**Fingallians GAA Club**  
**Lawless Memorial Park**  
**Swords**  
**Co. Dublin**  
**K67 NX02**

**TII Submission for the Railway (Metrolink-Estuary to Charlemont via Dublin Airport) Order**  
**2022**

**7th March 2024**

Drawing Title: **METROLINK - GENERAL ARRANGEMENT BALHEARY DEMESNE (SHEET 3 OF 5)**

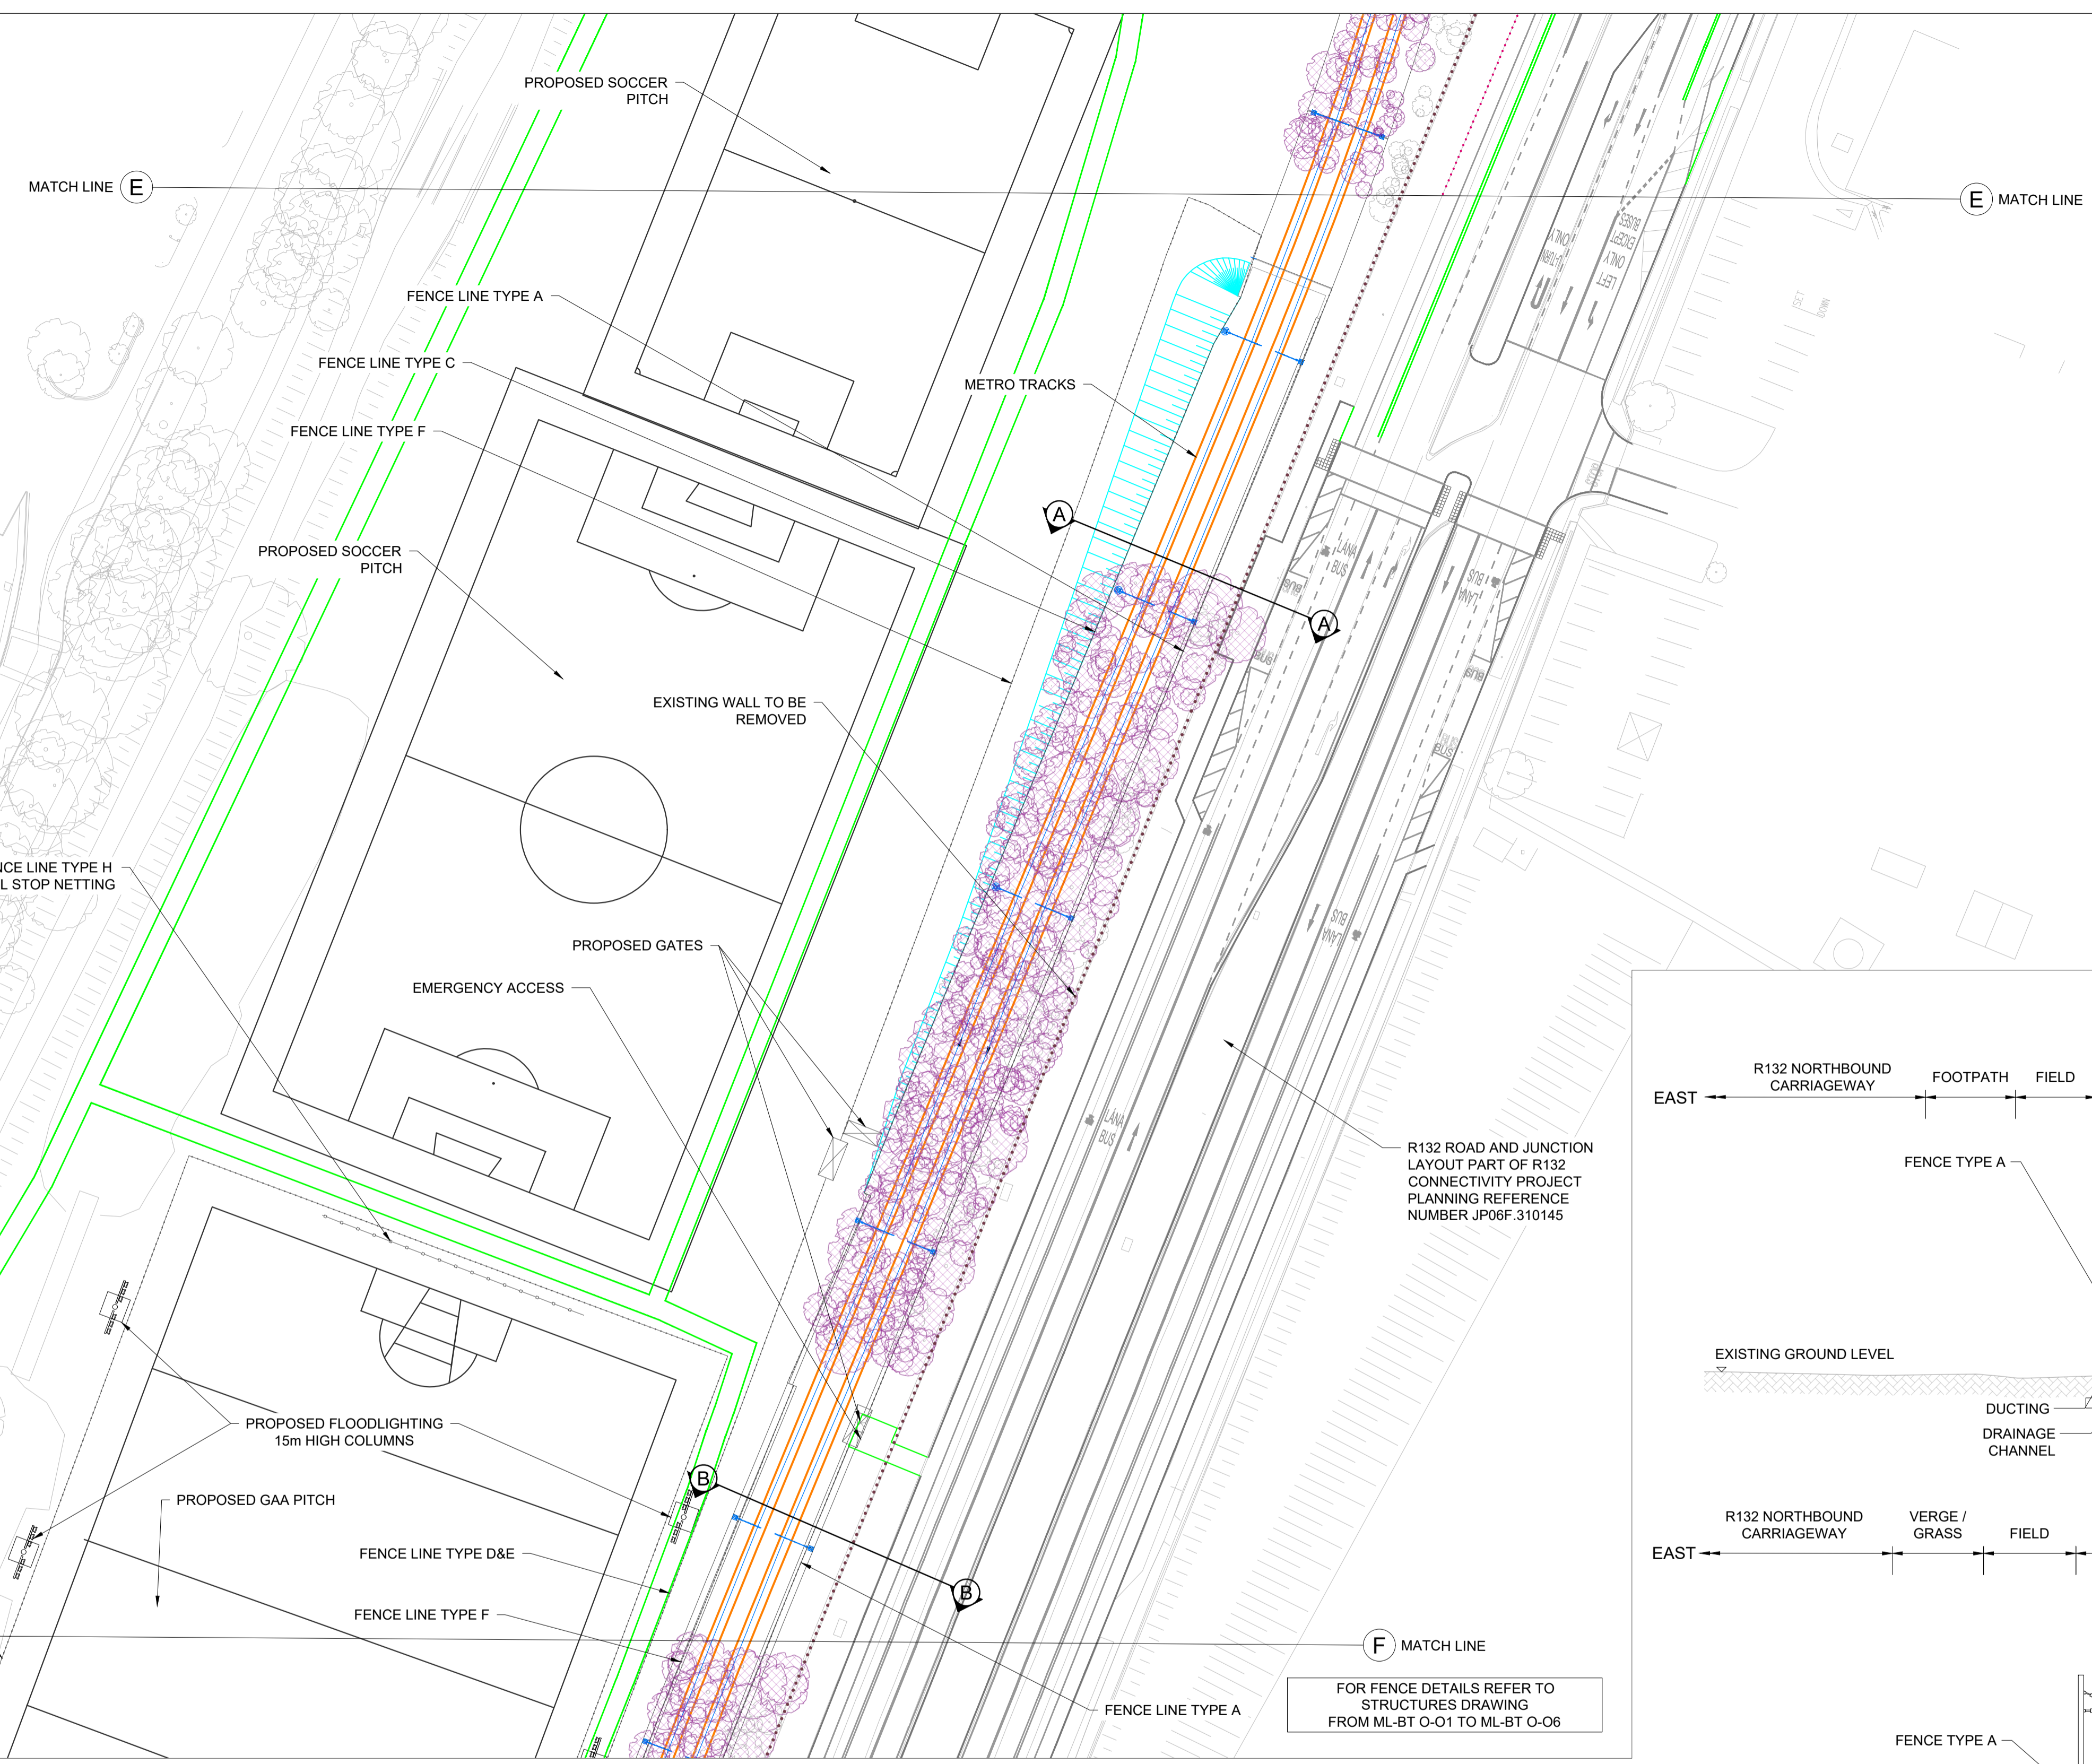
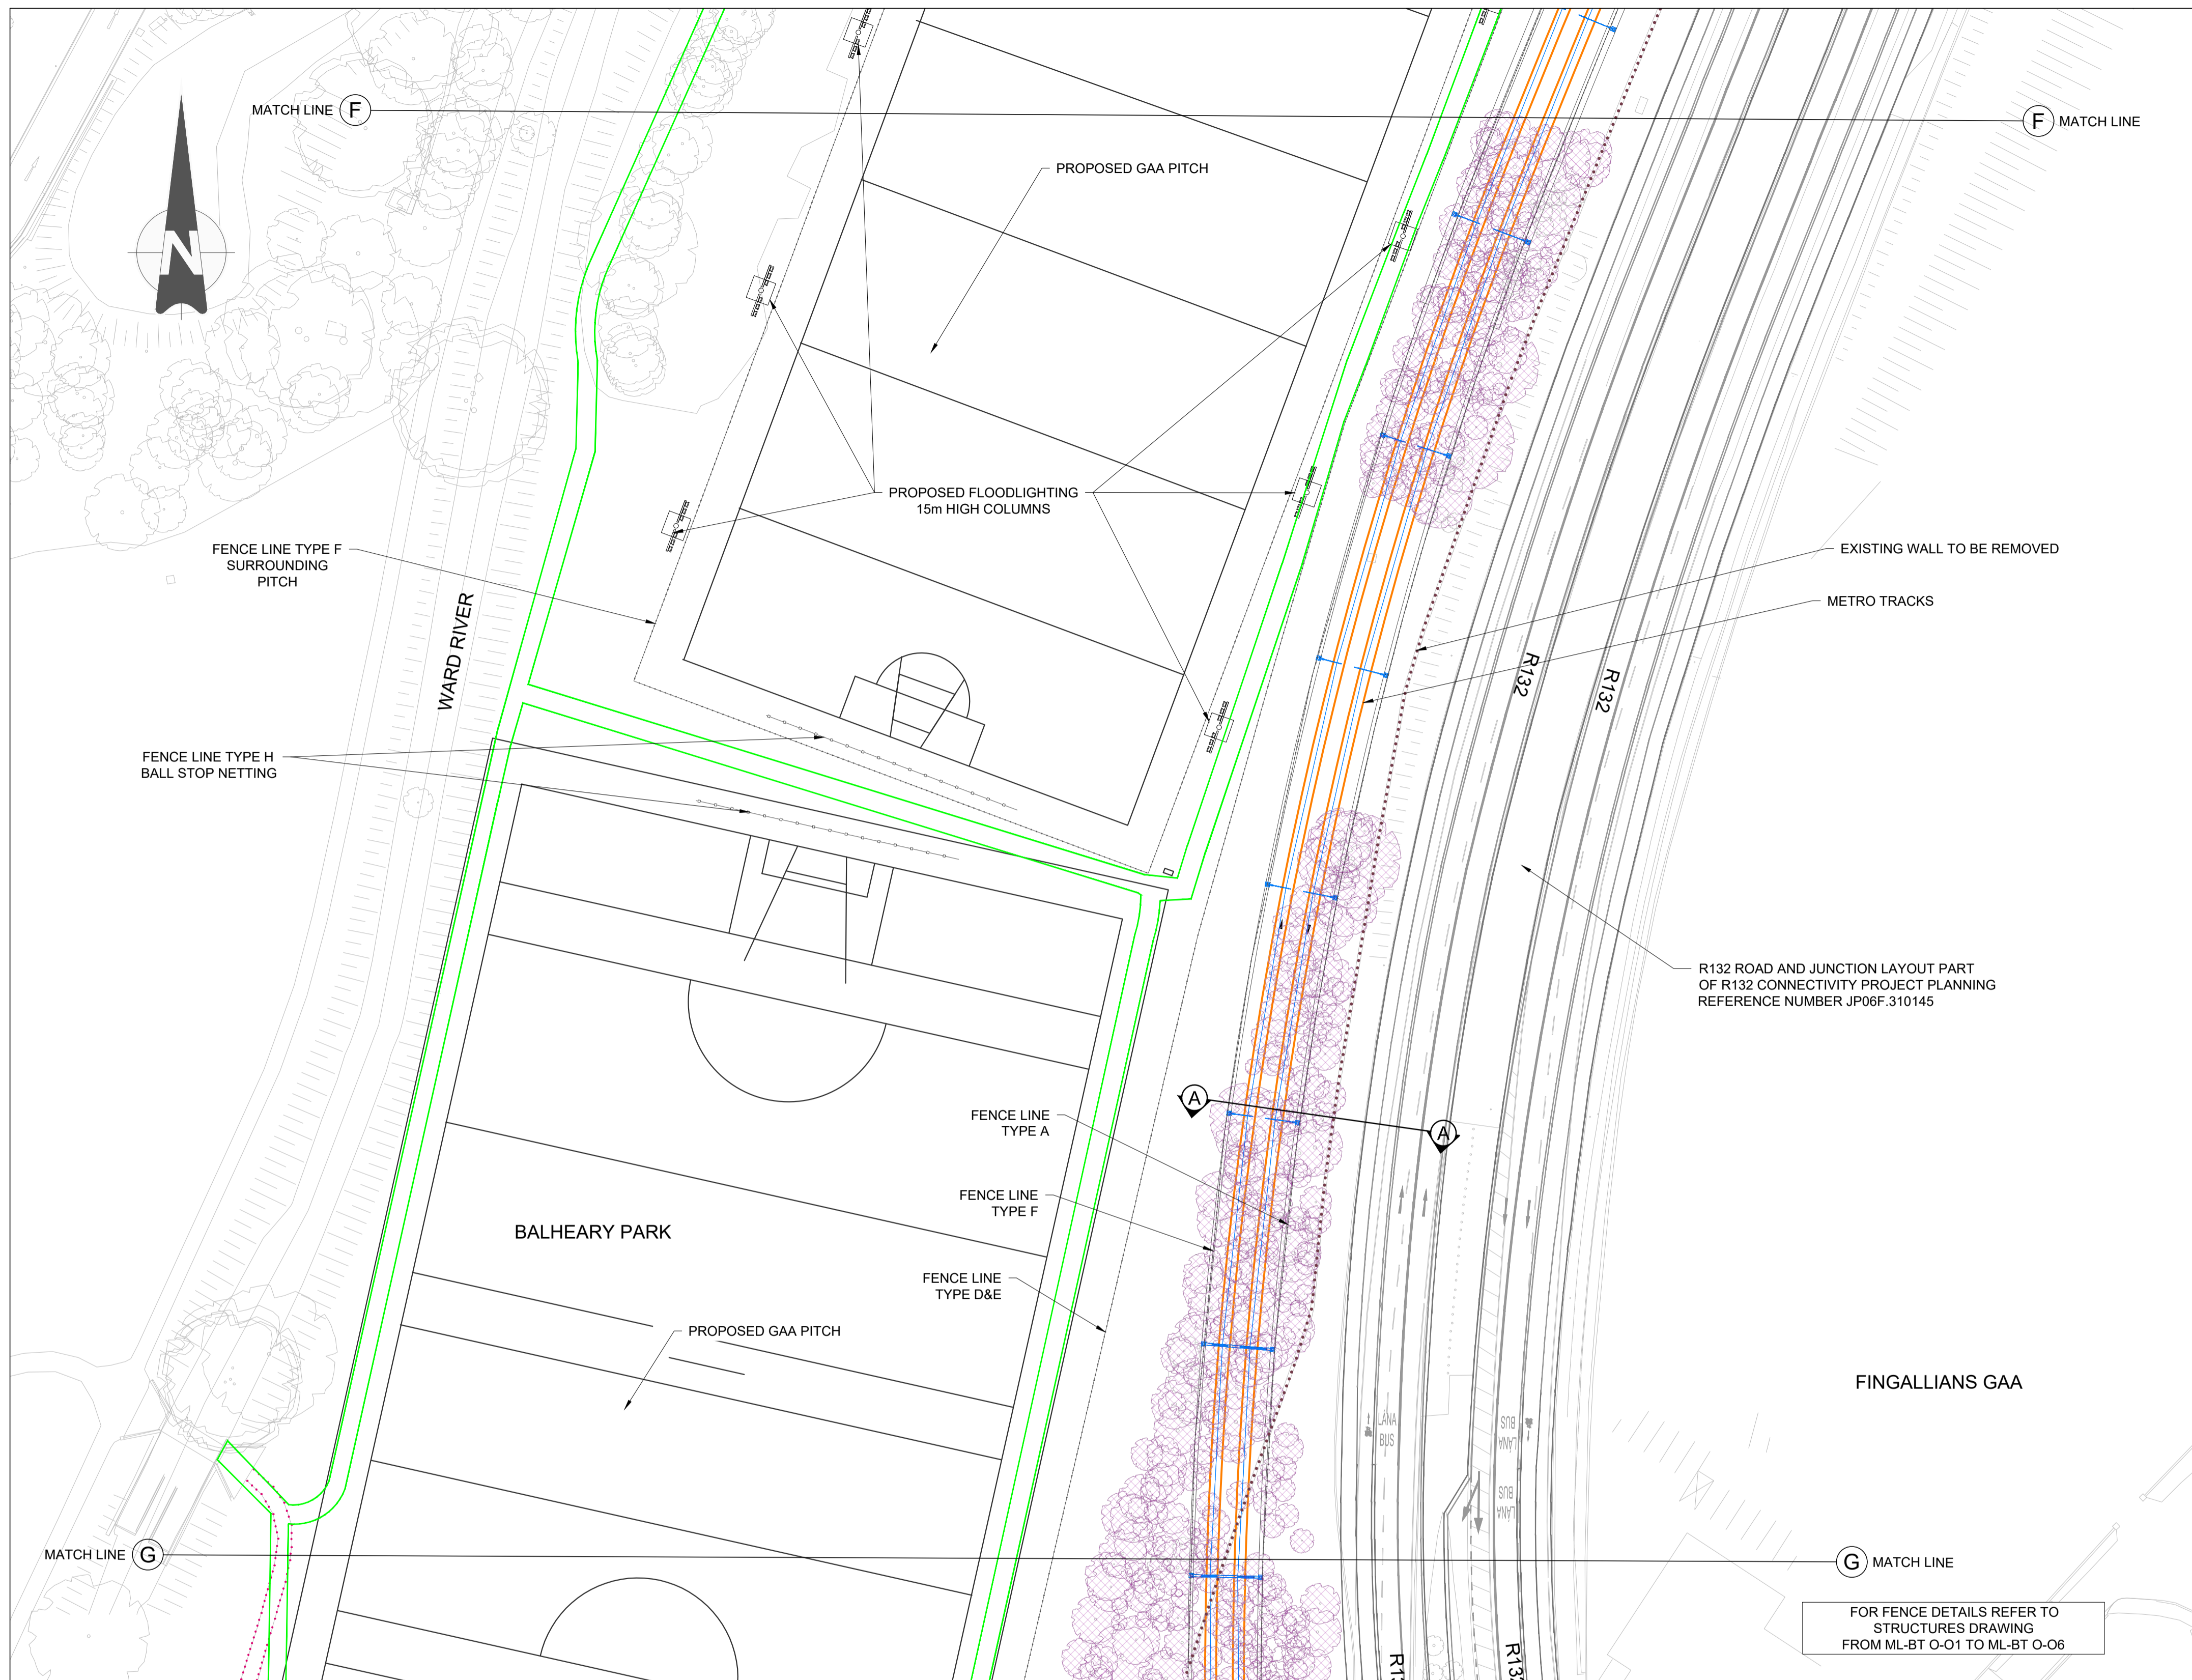
**At a minimum, the Club would expect no impact to existing facilities as a result of the development of Metrolink. The current plan results in the permanent loss of a full-size pitch in Balheary, which Fingallians has had exclusive access to for more than 40 years and in the short to medium term, will result in the loss of access to Balheary and its 2 full size pitches for the period of works.**

**Following an extensive engagement with TII, we require a guarantee to provide the club alternative facilities in the locality replacing the 2 impacted pitches in Balheary for the duration of the works. This is essential to ensure that Fingallians can continue to provide playing facilities for our ever-increasing playing numbers. Fingallians are continuing to work with TII on the final configuration of the Balheary pitches post project completion.**

- **Following extensive consultations with TII, we have a written commitment from TII to deliver one fullsize flood lit all-weather pitch and one juvenile grass pitch for exclusive Fingallians use in the**

**final configuration. This still represents a loss of one fullsize pitch on what we have had for more than 40 years.**

Proposed Final Pitch configuration in Balheary (1 Adult full-size pitch and 1 Juvenile pitch)

- Provision must be given to Fingal maintenance vehicles (grass cutting) and emergency access for an ambulance.
